From: Amanda Scholes on behalf of Planning.Responses
Sent: 20 November 2020 12:02
To: Planning Scanning
Subject: FW: 54 Arundel Road Littlehampton BN17 7DD - LU/284/20/PL

Planning Reference: LU/284/20/PL

Proposal: Demolition of 3 No. garages & erection of a four-room house of multiple occupation with shared facilities & parking for 3 cars (resubmission of LU/125/19/PL).

Address: 54 Arundel Road Littlehampton BN17 7DD

GROUND FLOOR PLAN PROPOSED

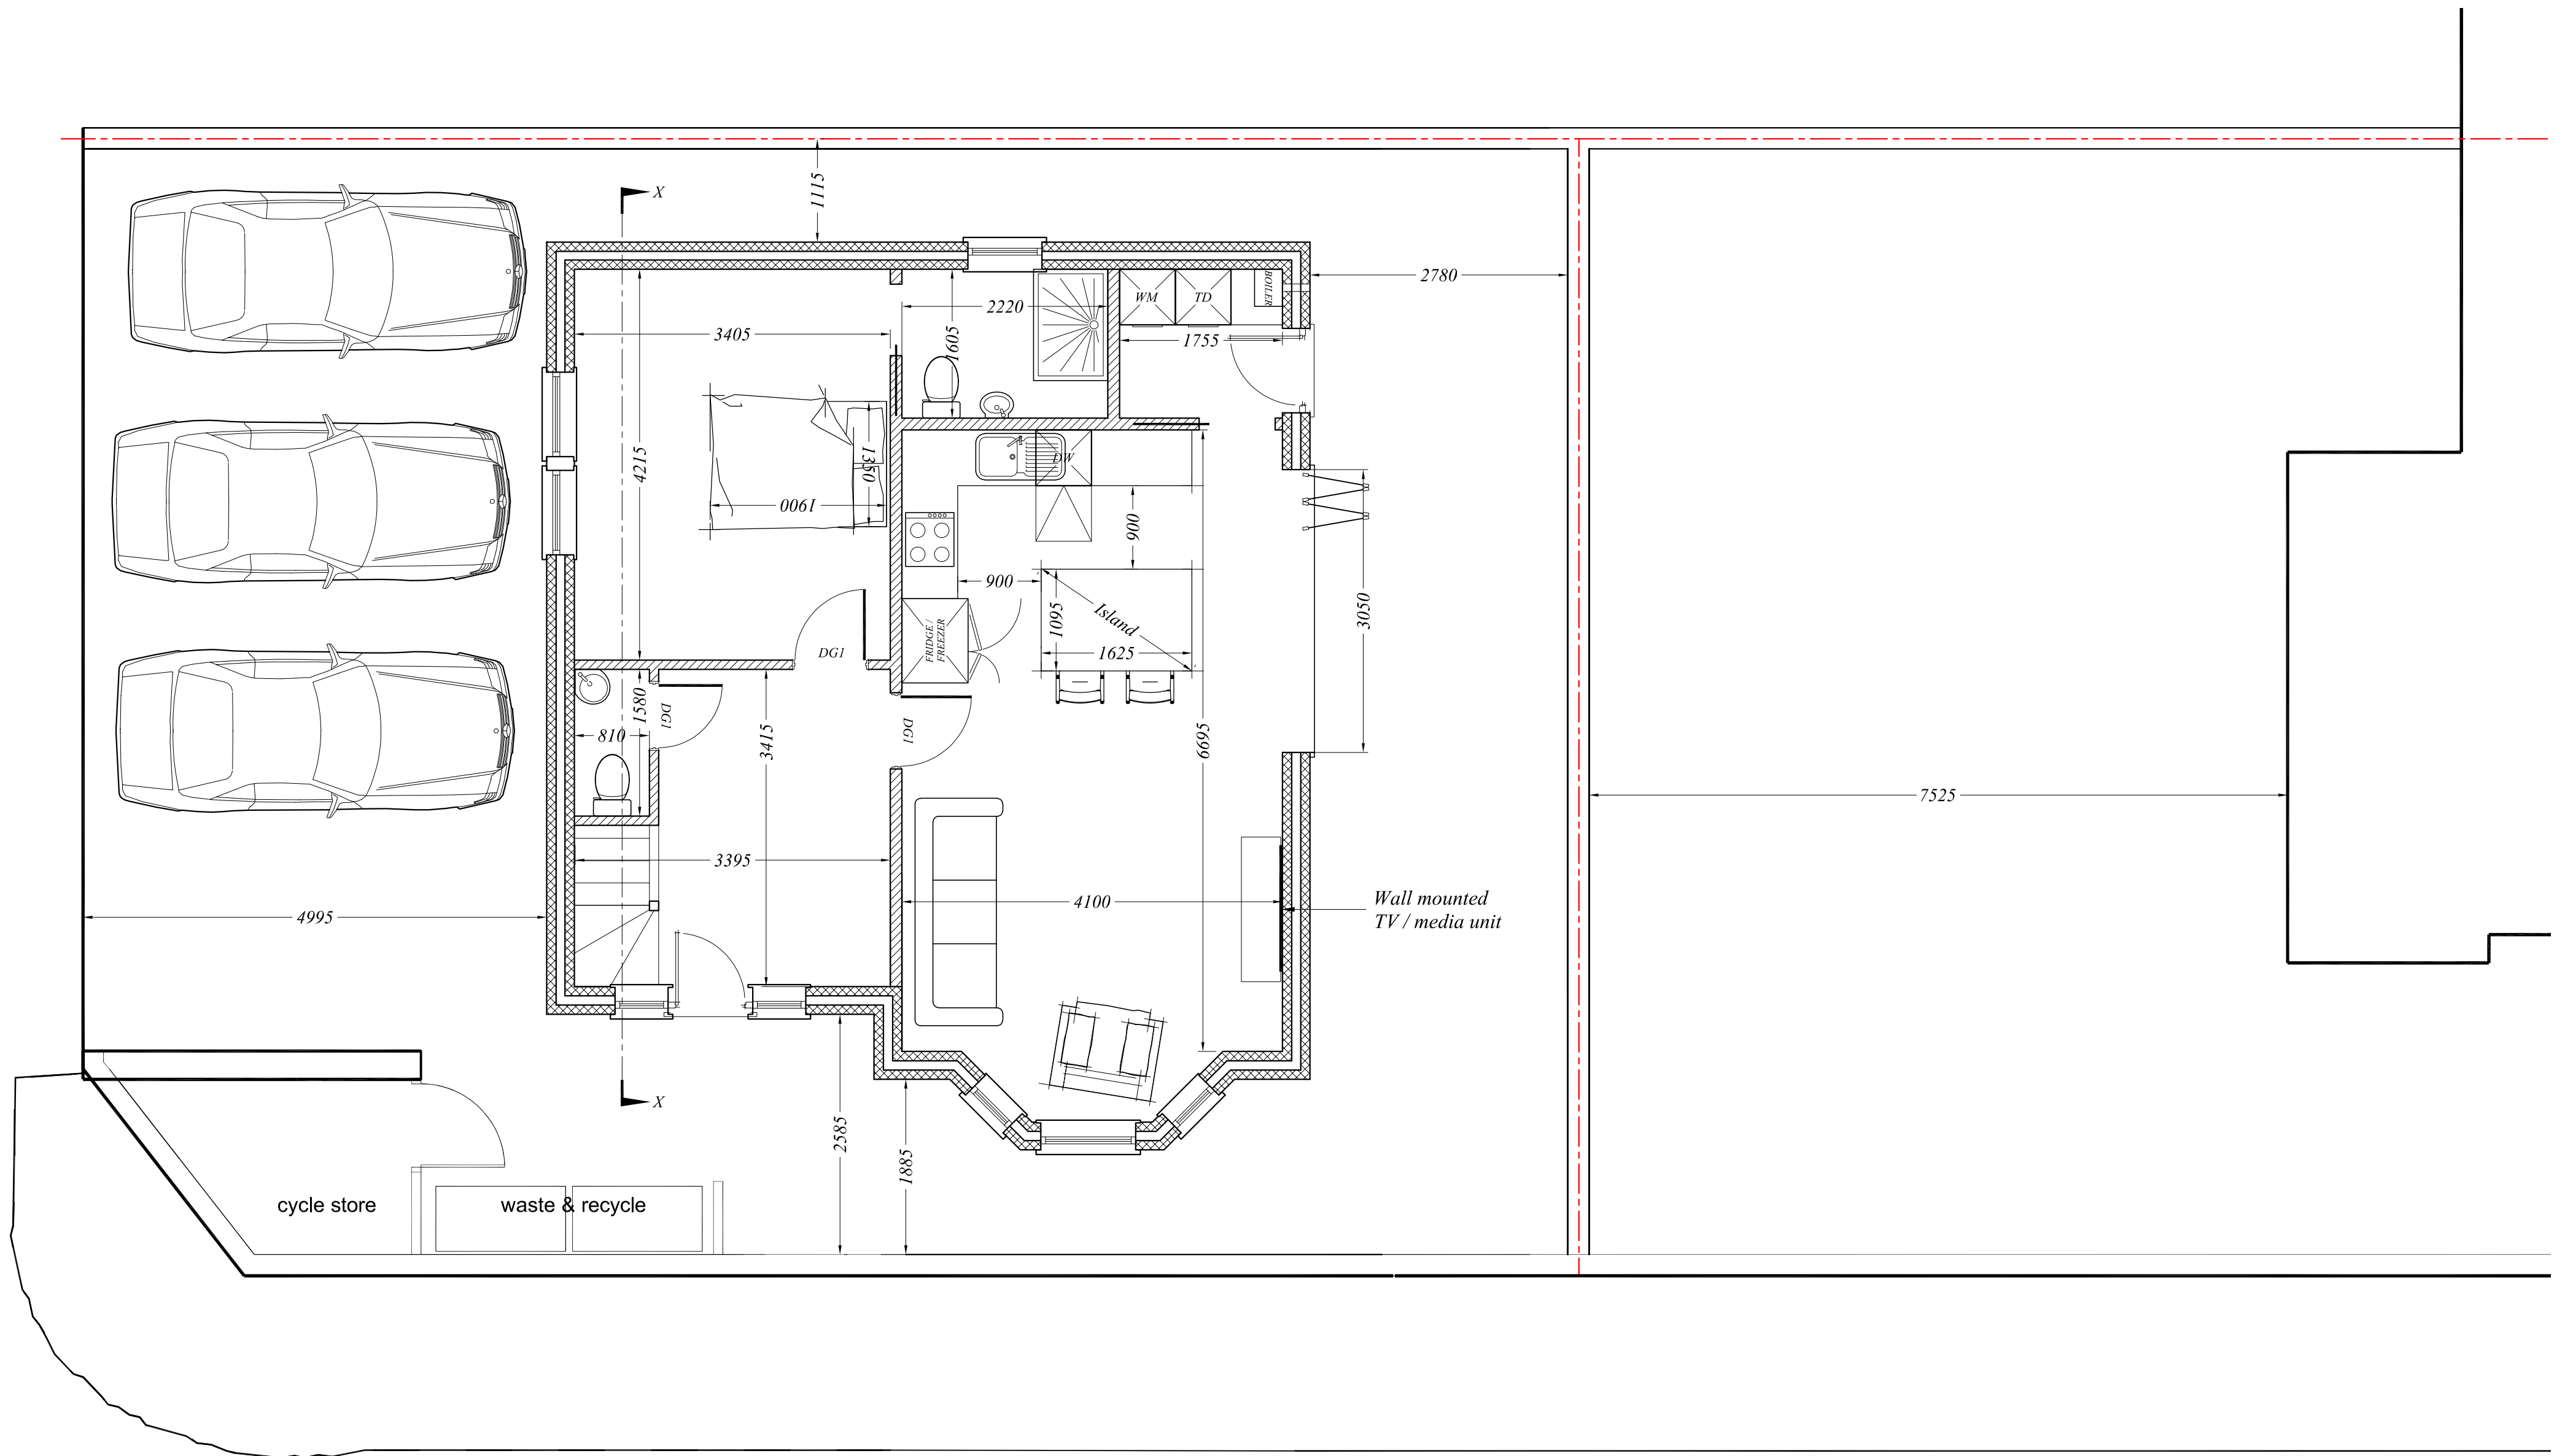
I note from the proposed site plans that Bedroom 3 will be located above the kitchen and that Bedroom 4 will be located above the living room. Such incompatible adjacent room types are highly likely to give rise to noise complaints in the future. As the layout of the building is such that these incompatible room types are vertically adjacent to each other, it is likely that uprated acoustic measures will be required in the ceilings/floors to mitigate against noise transfer.
